RE WORTLEY VILLAGE PLAN

Following our site meeting at Wortley Village on 20th October 2016. Please find attached the following drawings revised as per our onsite discussions.

**SCALE** 1:100 @ A1  
**DATE** JAN 2016  
**JOB NO.** 04-02  
**DRAWING NUMBER** P1  
**REV**

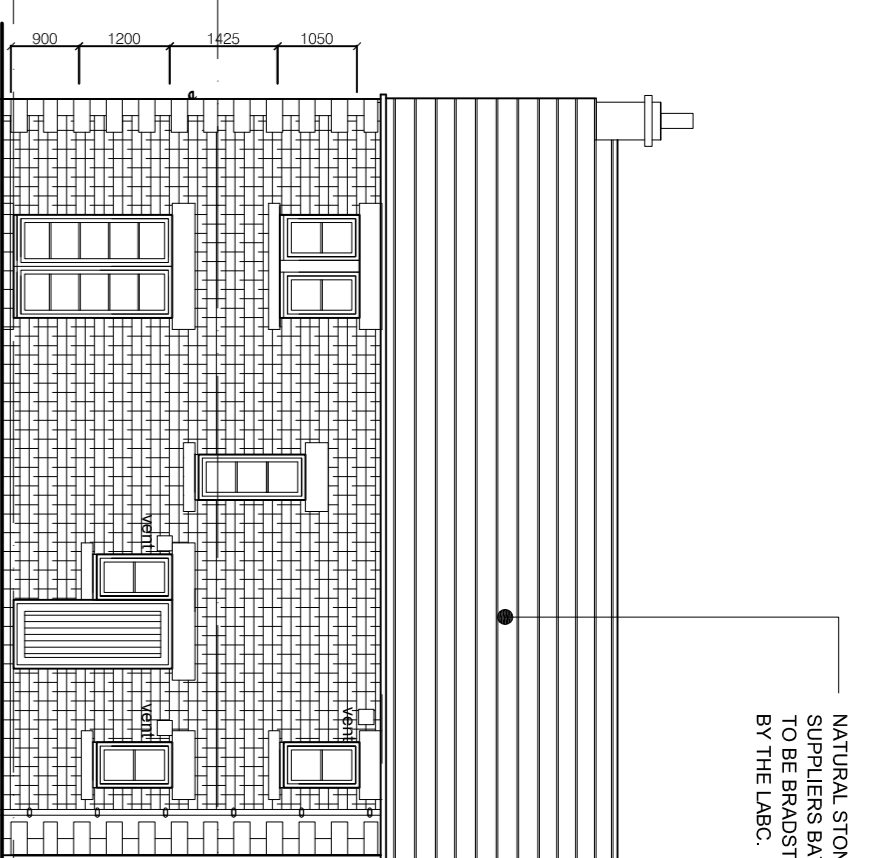
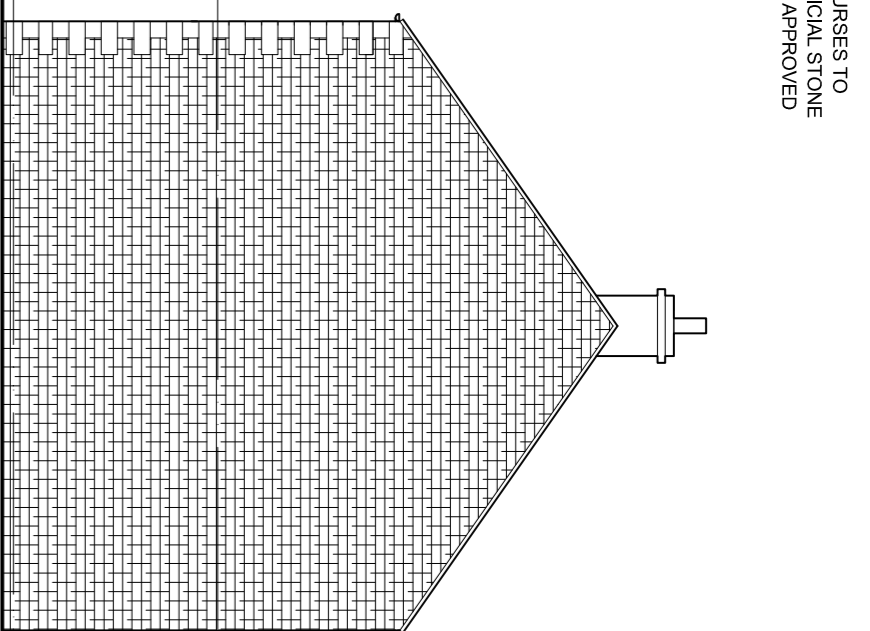
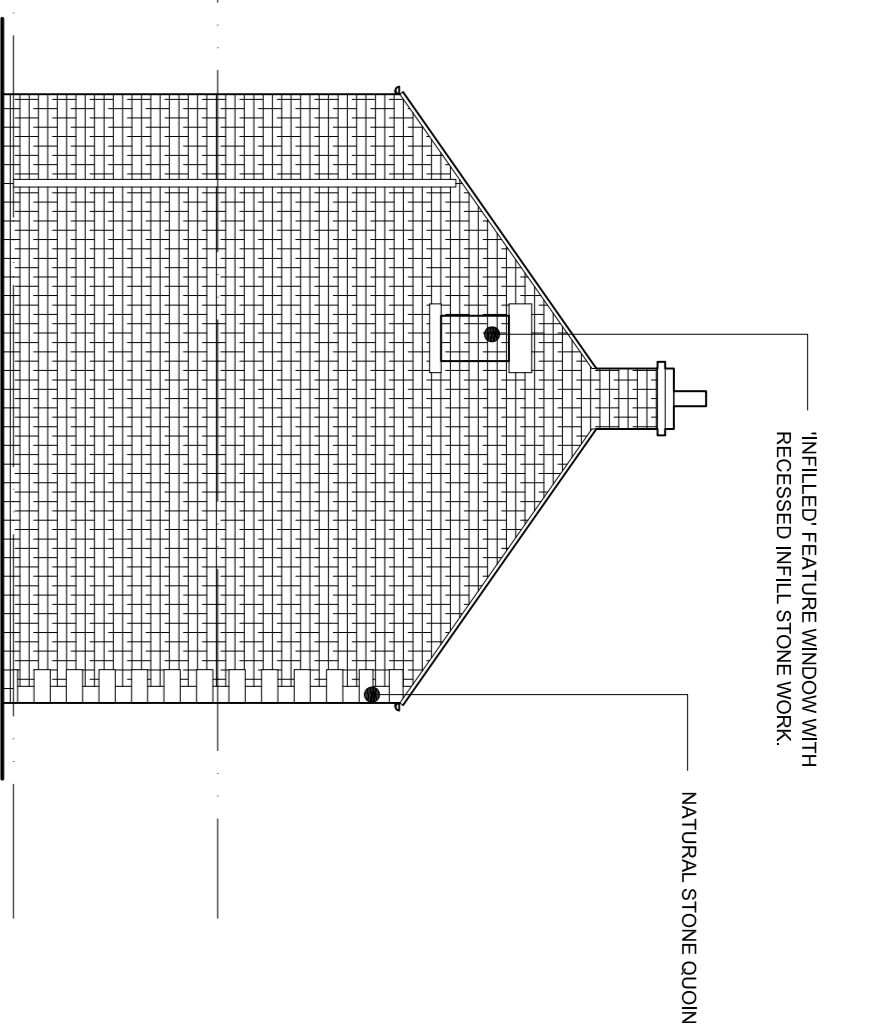
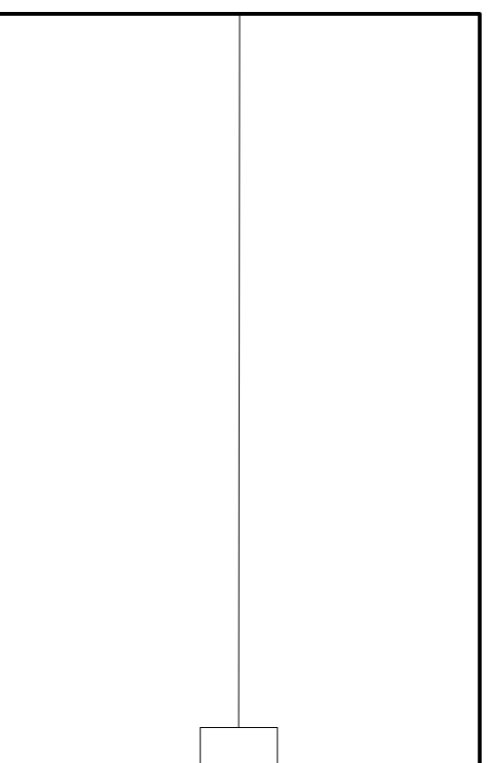
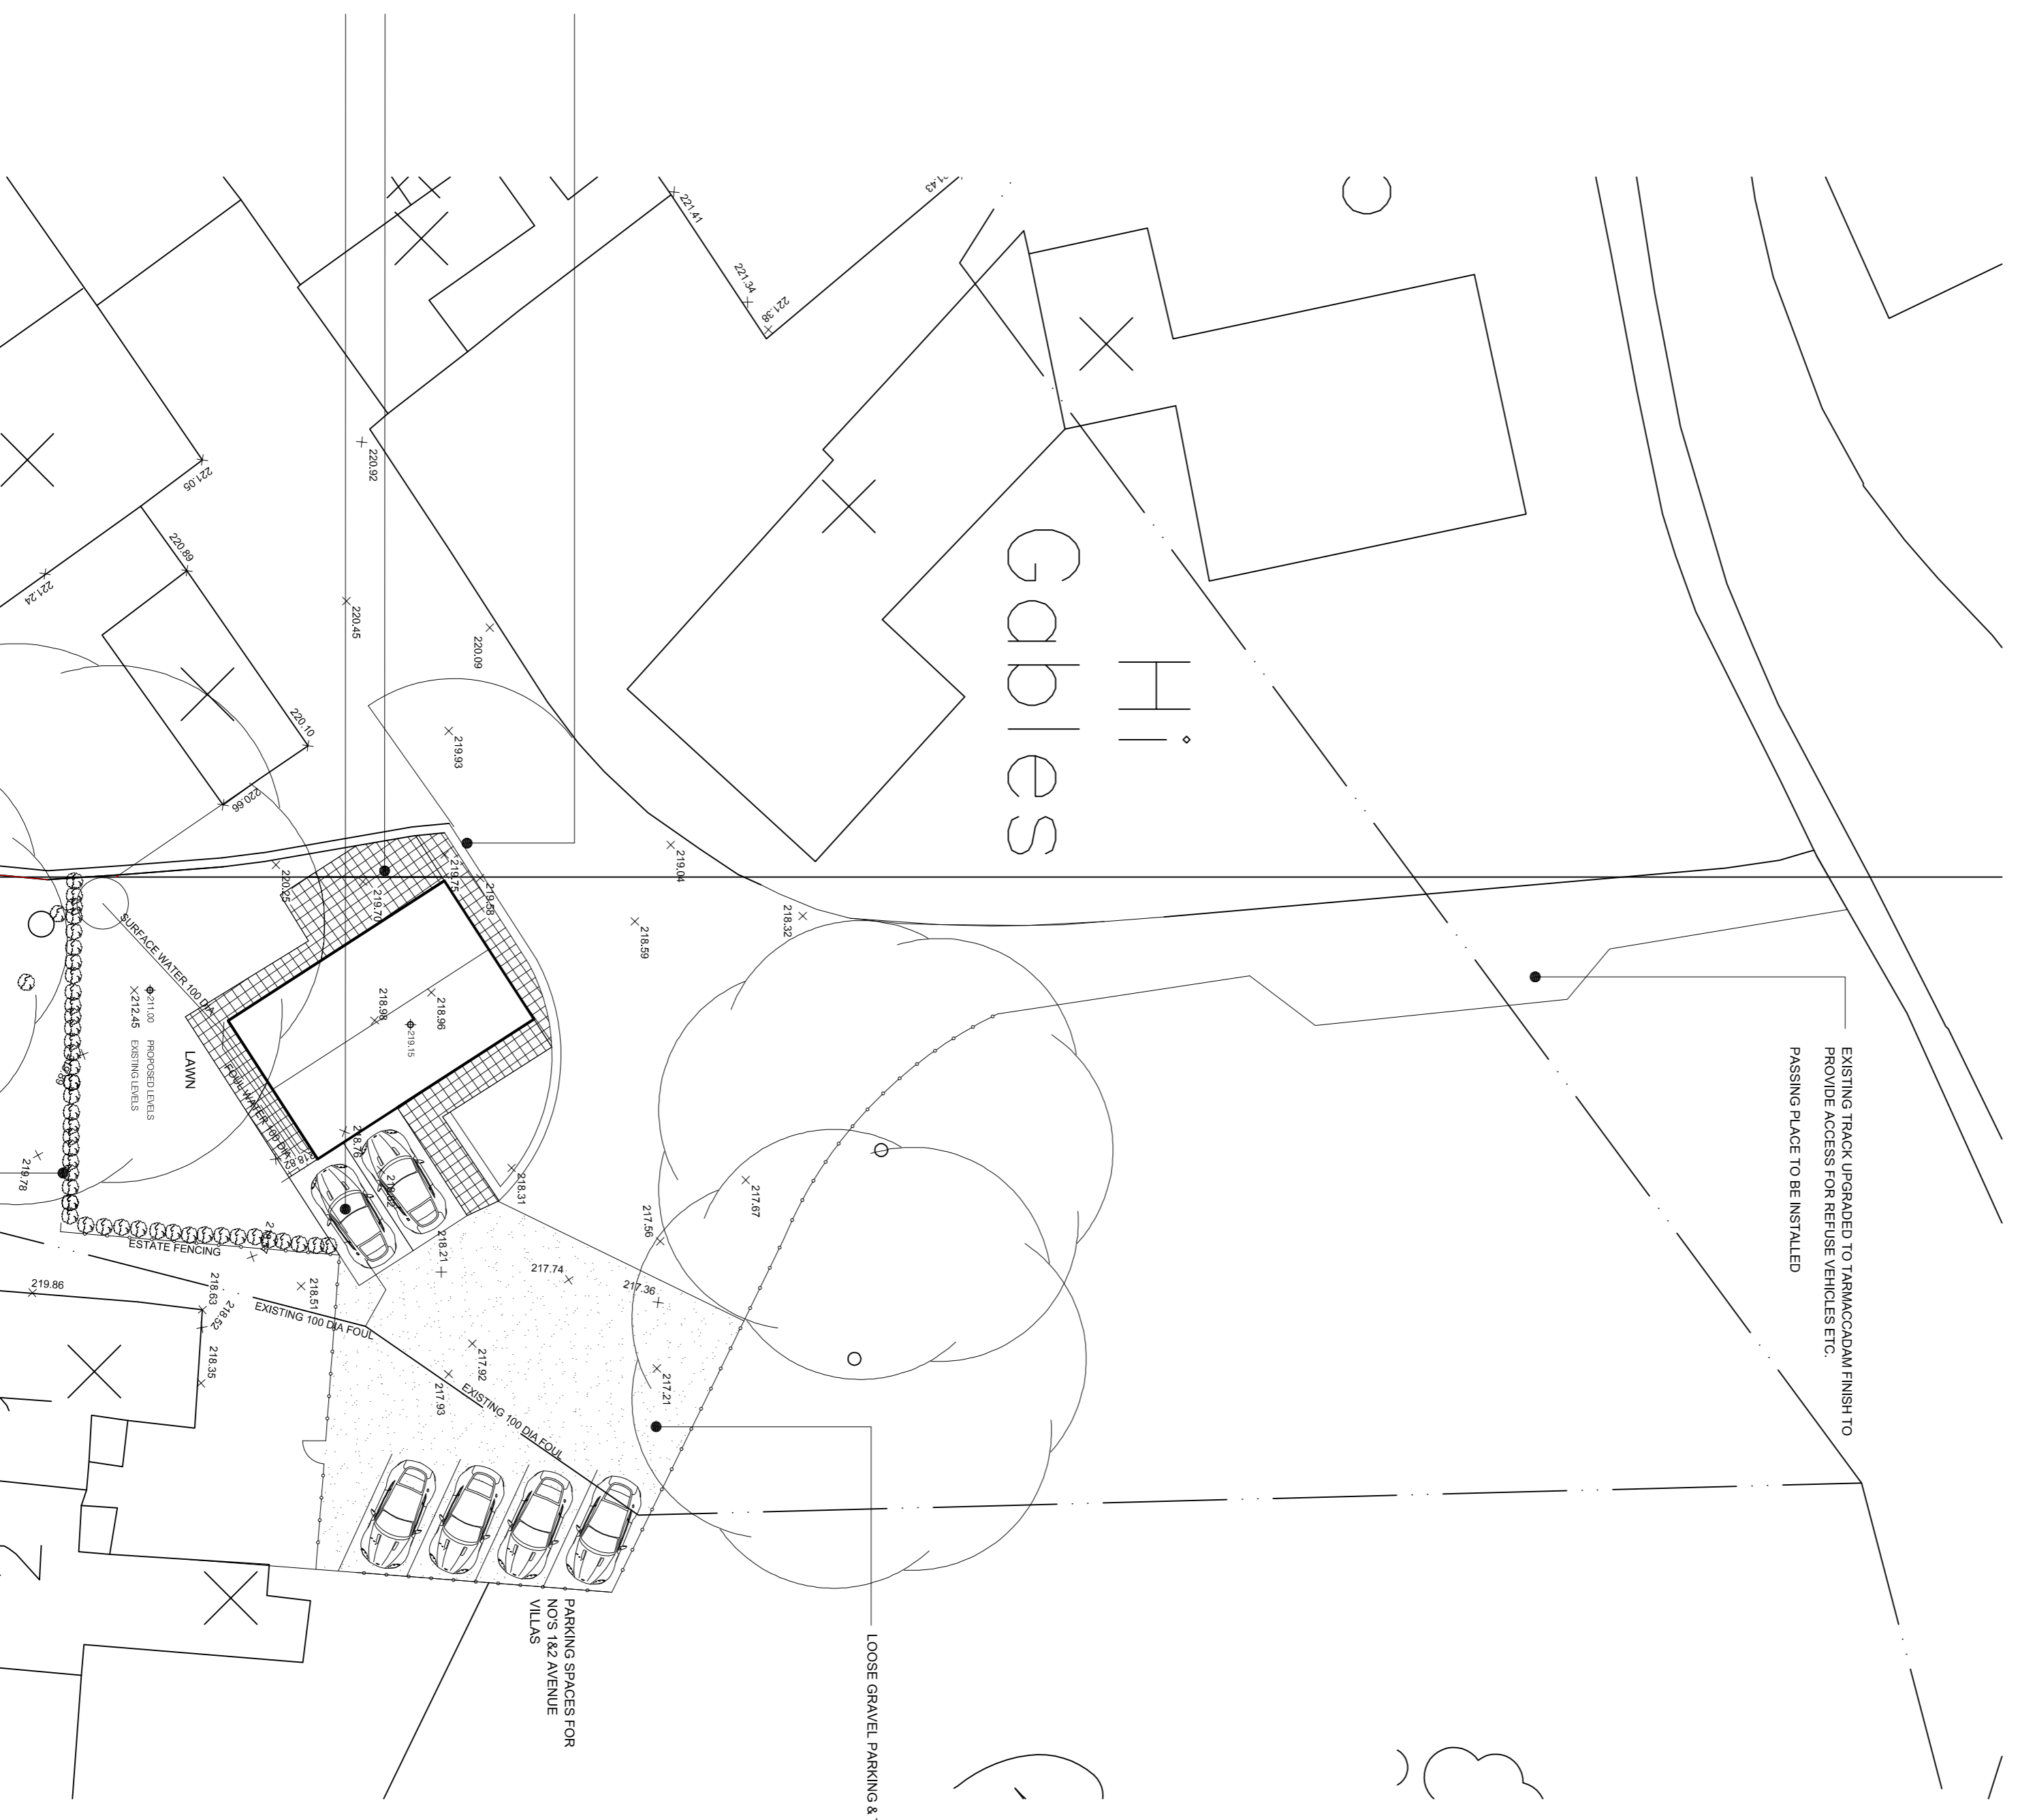
- 707-04-02-P1** Revised to confirm gutter details & additional feature to gable wall.
- 707-07-02-P1** Connection between garages added to form courtyard appearance. Gutter details added. roof detail amended to include stone courses below slate as localised detail.
